Your Ref: A/23/18/DOC

18 July 2018

Town & Country Planning Act 1990 (as amended)
Town and Country Planning (Development Management Procedure) (England) Order 2015
Approval of matters reserved by condition imposed under A/27/16/PL relating to conditions 7-
Construction Management Plan & 19-Tree Protection Measures.
Broadlees Dappers Lane, Angmering,

Arun District Council have decided to **REFUSE details reserved by condition for the following reasons:**

Permitted Extra Care Development, Dappers Lane, Angmering
Construction Management Plan

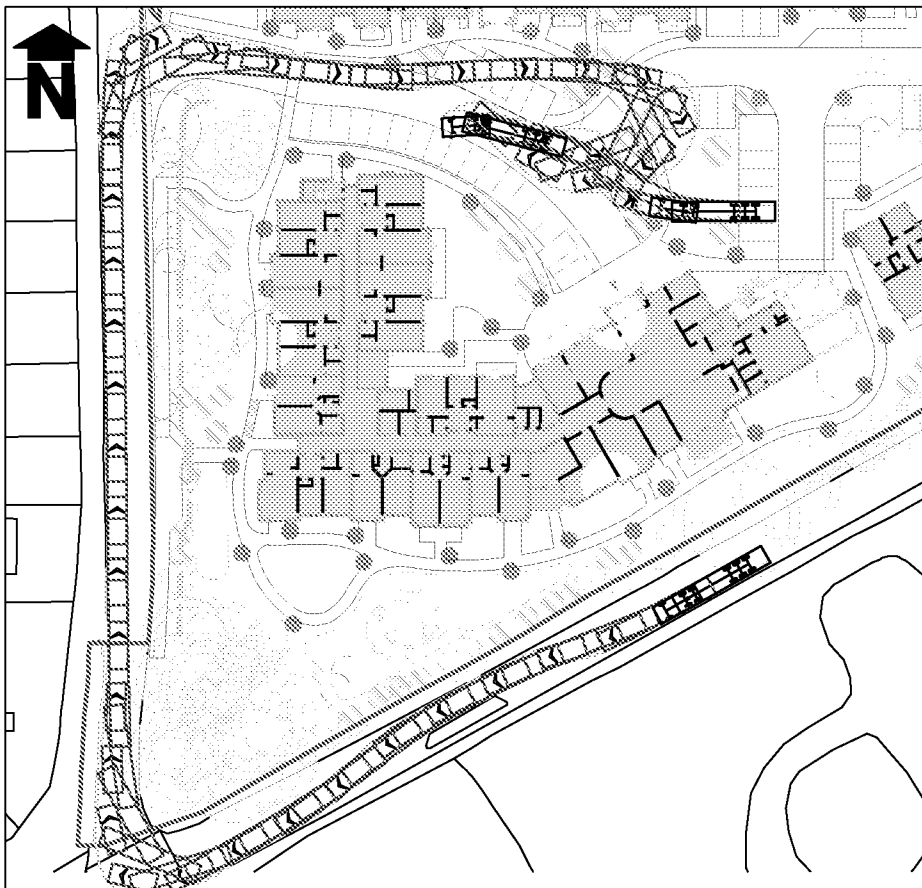
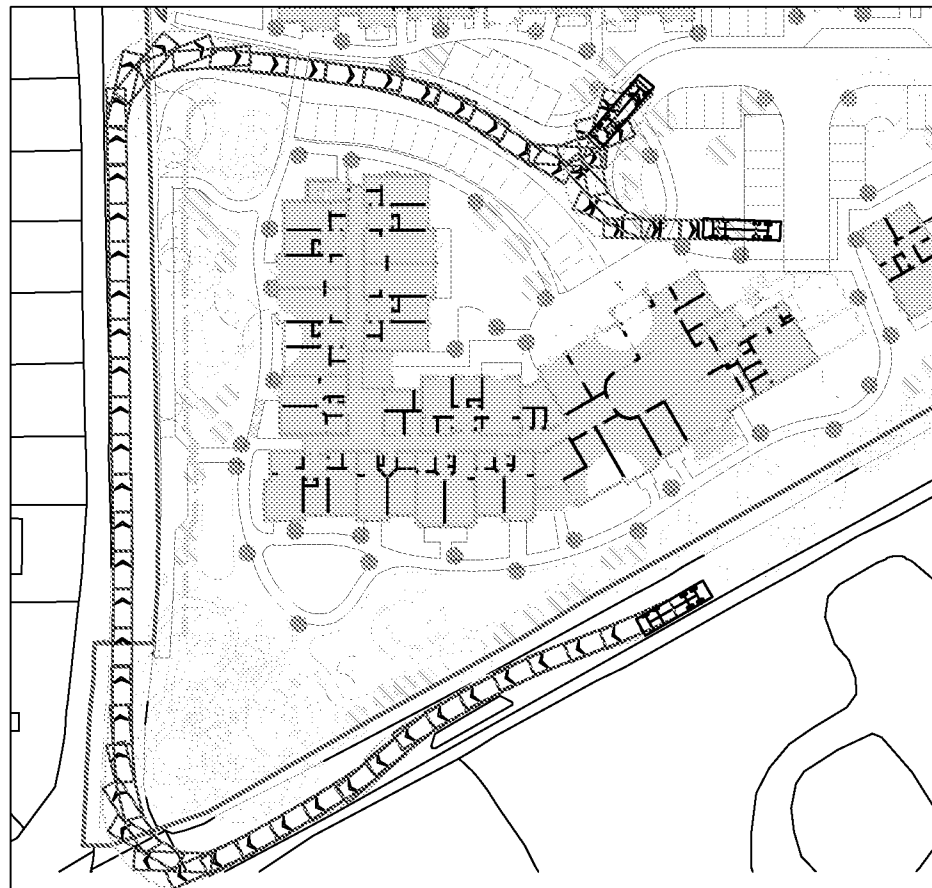
The Construction Management Plan provided by Peter Evans Partnership dated February 2018 is limited since a building contractor is yet to be identified.

Further detail is requested as to the precautions which will be taken to minimise potential disturbance to neighbouring sensitive receptors during the demolition and construction phases of the development, particularly with respect to noise, vibration and dust. This is to include detail of the proposed method should foundation piling occur, the careful siting and selection of plant and machinery to reduce noise the detriment and as necessary the use of noise mitigation barriers. Whereas the covering of loose loads to lorries and wheel washing

are detailed, the Management Plan should also include detail of those measures which will be applied to the whole of the site which aim to prevent dust detriment to nearby sensitive receptors during the demolition and construction phases.

Whilst the Highway Authority has no objections in principle to the approval of this application prior to discharge of the condition the Highway Authority would look for the applicant to commit to undertaking a condition survey of the highway prior to commencement and to invite a member of the WSCC Area Office to be in attendance during the initial survey. Should any damage to the highway occur that is caused by the activities associated with the demolition or construction of the development the Highway Authority would look for these to be addressed. The applicant is advised to contact the Arun Area Highway Office (01243 642105) in order to commence this process.
